(Development Charges Letter)

File No. : CMDA/PP/NHRB/S/1143/2019

Sir,
Sub: CMDA-Area plans Unit - 'B' Channel (South) – Planning Permission application for the proposed construction of Stilt floor + 4 floors (17.70 m height) Office use commercial building at LB Road and 1st Avenue, Shastri Nagar, Adayar, Chennai in T.S.No.3/1 (pt), Block No.22 of Urur Village within the limit of Greater Chennai Corporation - Remittance of DC & Other charges – DC advice Sent - Reg

**SITE CUM STILT FLOOR PLAN**

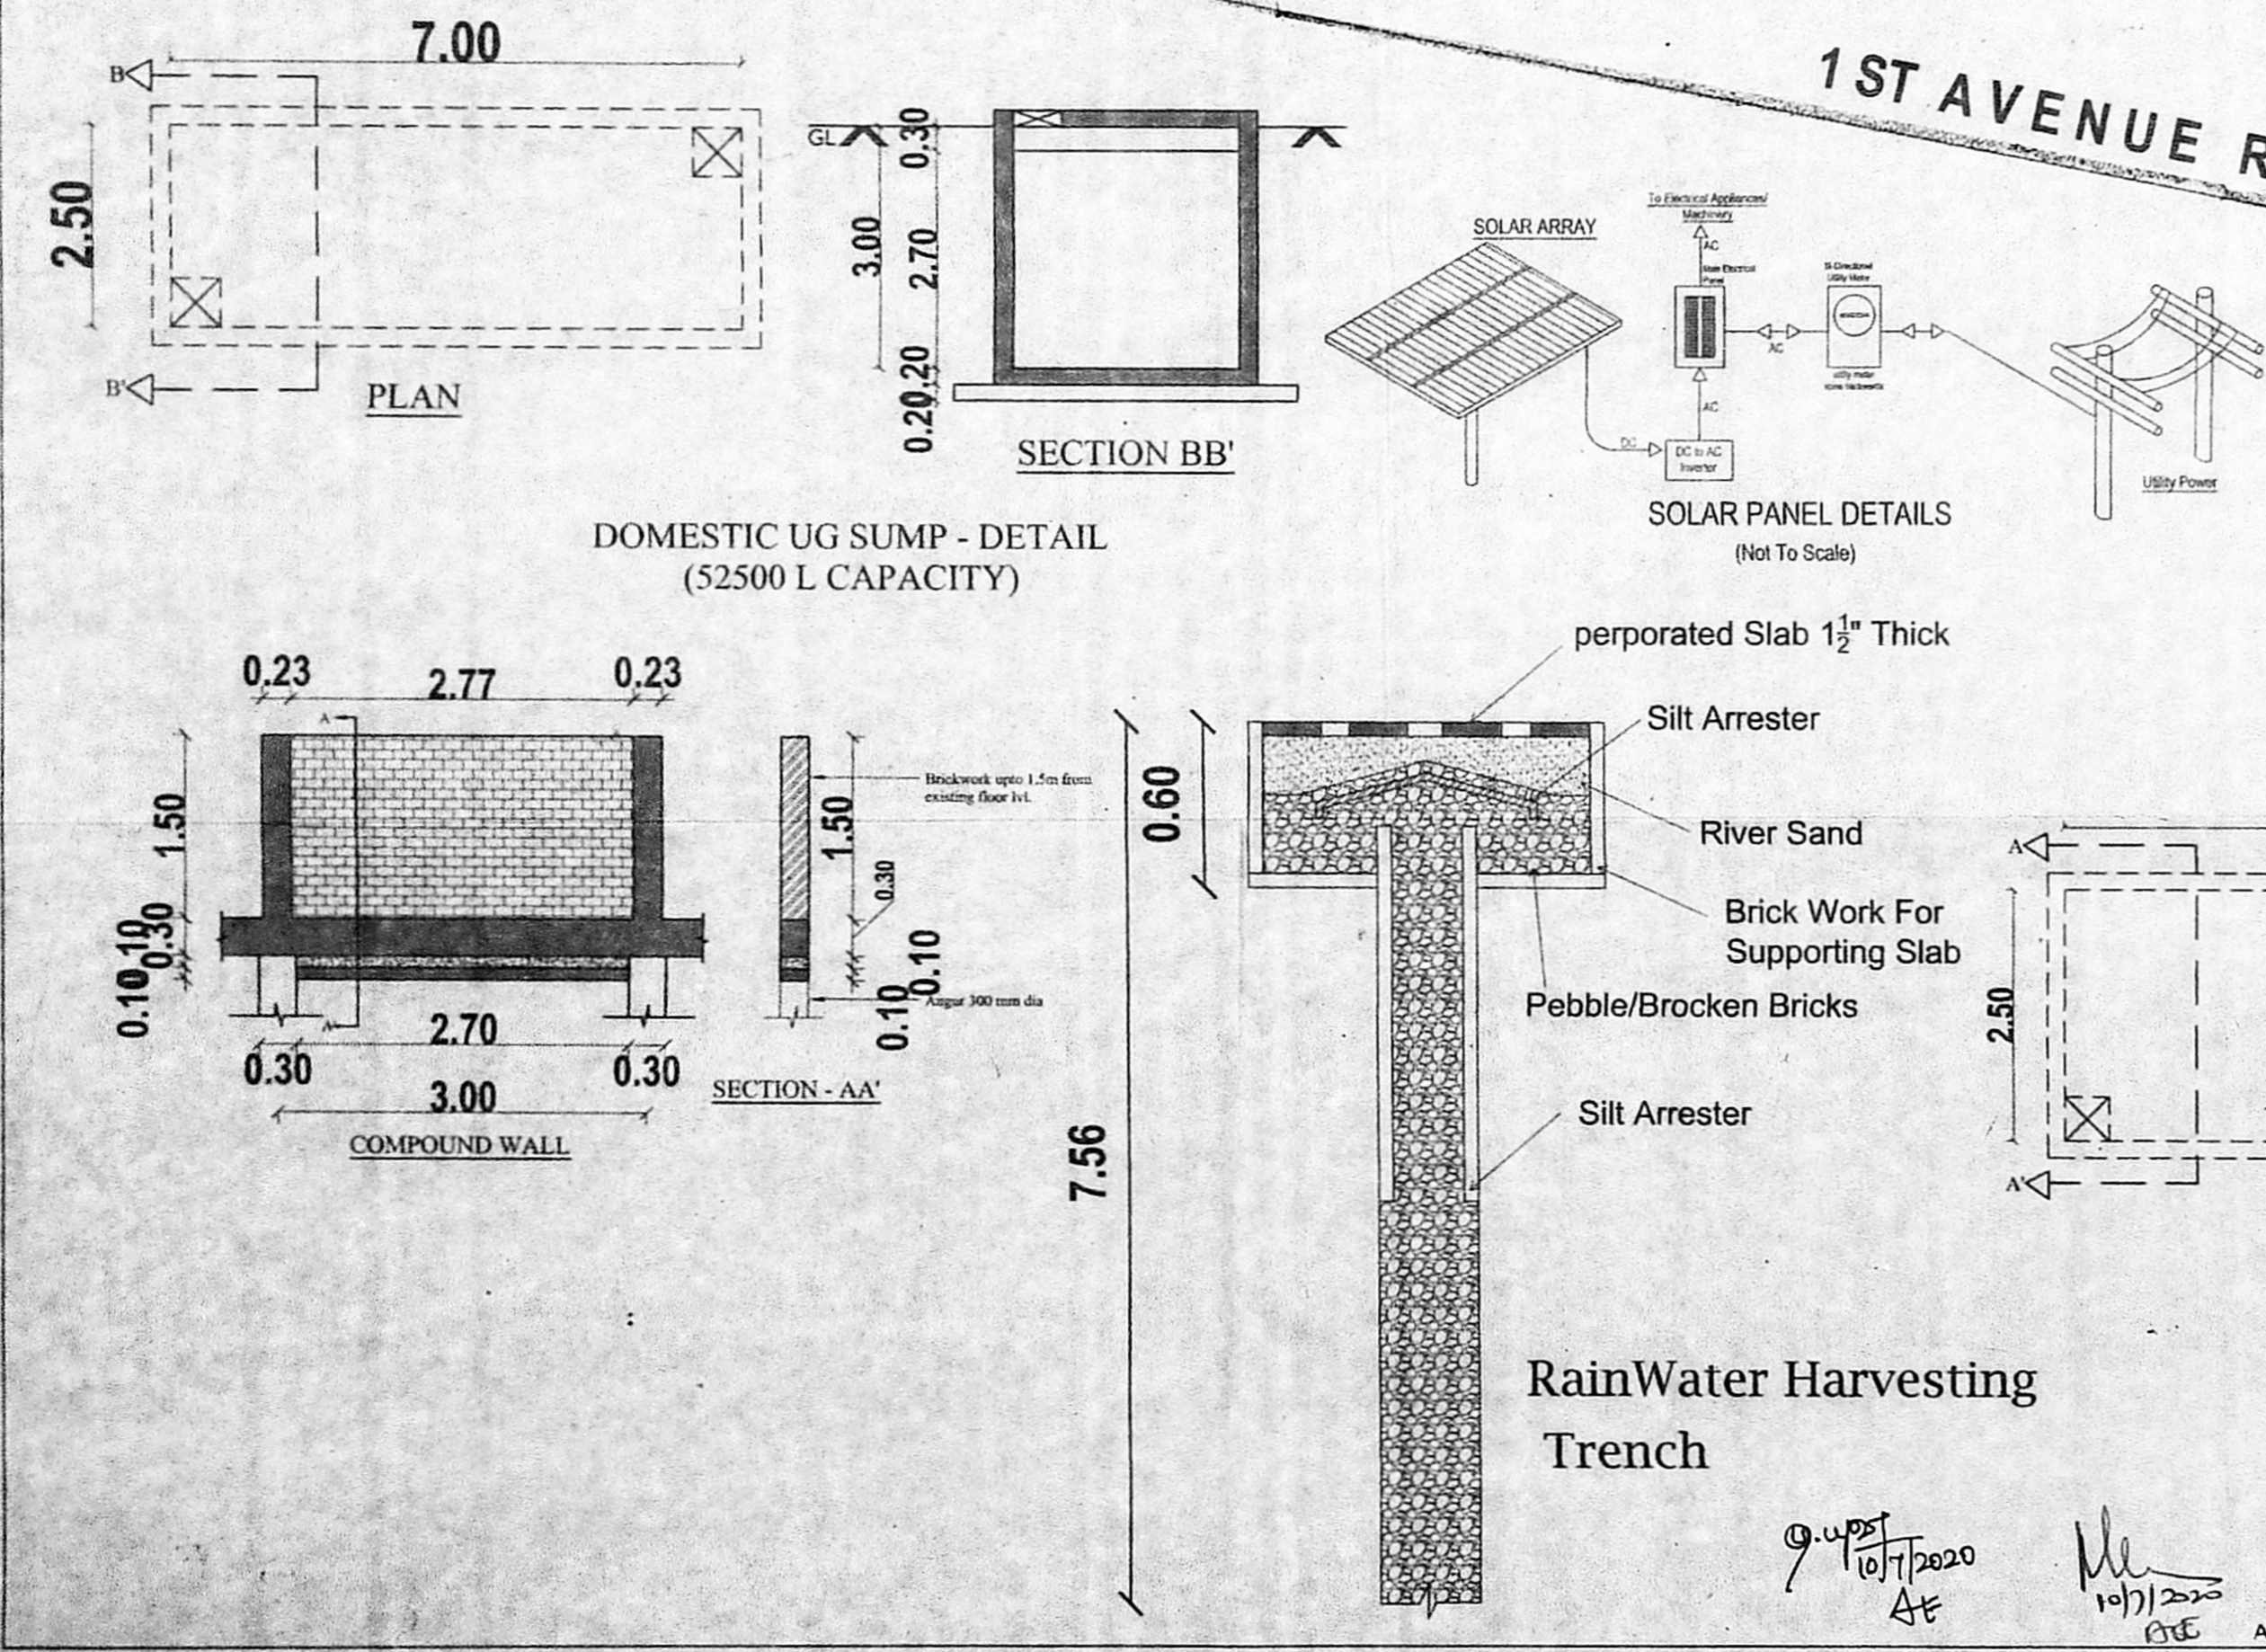
- Plans are to be signed by Registered Developer, Registered Architect and Registered Structural Engineer registered in CMDA.
- Stilt Floor to be shown in dotted line.

- Rain water harvesting as TNDCBR to be shown
- Rain water harvesting as TNDCBR to be shown
- Upper floor projection line to be shown in the site plan and setbacks from Upper floor projection line to be shown.

- Splay 4.5m x 4.5m to be shown as per TNDCBR.
- Sufficient Turning Radius and Aisle width to be shown in the site plan.
- Special provision for physically challenged person as per TNDCBR to be shown main title and area statements needs correction.

- Dimensions of Street Alignment portion to be shown in the site plan. the street alignment portion to be gifted to CMDA through a registered gift deed at free of cost.
